Date: 09 February 2022
Our ref: 377597
Your ref: P/167/21/RES & P/153/21/RES

Planning consultation: Reserved Matters (appearance, layout, landscaping & scale) for outline P/140/16/OUT for the erection of 375 dwellings, together with public open space, play space etc.

Location: Land South of Summer Lane and West of Pagham Road Pagham.

SUMMARY OF NATURAL ENGLAND'S ADVICE

Landscape General Arrangement Plan
1 of 5

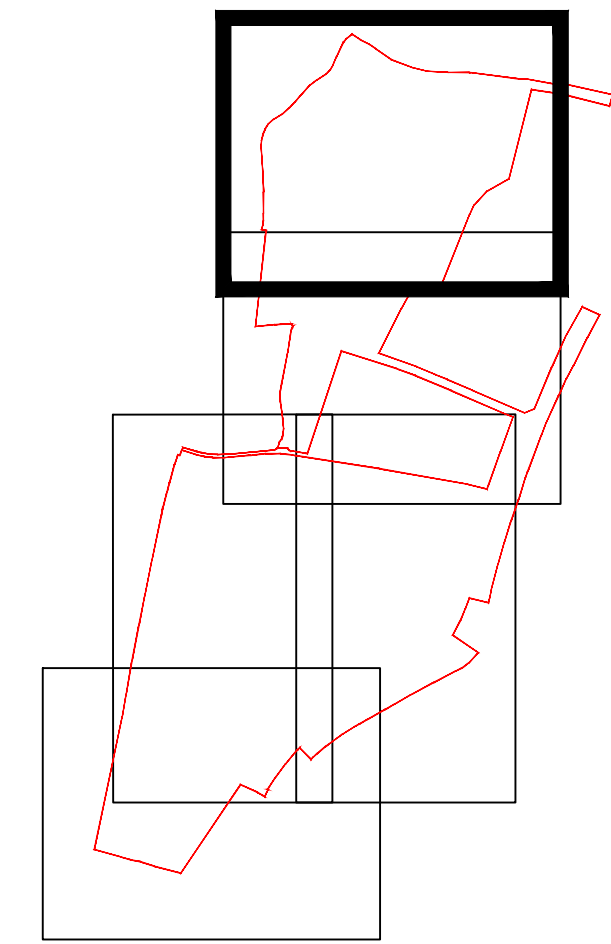
- How suitable screening and on-site greenspace have been incorporated into the landscaping plan.

As per our response on the Outline application P/140/16/OUT (our ref: 259977, 18th October 2018), Natural England advised that given the history of Brent Geese foraging in the fields to the west of the application site, the landscaping plan should include details of thick hedging, reinforced by fencing, along the western boundary of the site. Having reviewed the information provided under this Reserved Matters application, it remains unclear as to how this advice has been incorporated within the landscaping design.

Given that the screening forms part of the suite of mitigation measures required to rule out an Adverse Effect on the Integrity of the Pagham Harbour designated sites, Natural England would advise that this information should be provided by the applicant and secured in perpetuity by your authority. Where this is not secured, there is a risk that the efficacy on the on-site greenspace is undermined by the absence of suitable places for residents to safely let their dogs off leads without adversely impacting the designated sites.

In addition to the uncertainty surrounding the inclusion of suitable screening along the western boundary of the site, it is equally unclear as to whether the current layout of the site is able to facilitate the proposed 3.92ha of on-site greenspace within the development site. Whilst Natural England recognises that consideration has been given to its management of the greenspace within the S106 agreement for the Outline application, having reviewed the proposed block plan for the site it is unclear as to how 3.92ha of on-site greenspace shall be appropriately accommodated within the proposed layout.

Given that the on-site greenspace and screening measures form part of the suite of mitigation measures, as per the requirements of an Appropriate Assessment, there can be no uncertainty associated with the value of a proposed means of mitigation. As such, we would advise that permission should not be granted until your authority is able to be certain that all appropriate means of mitigation can be accommodated and secured in perpetuity.
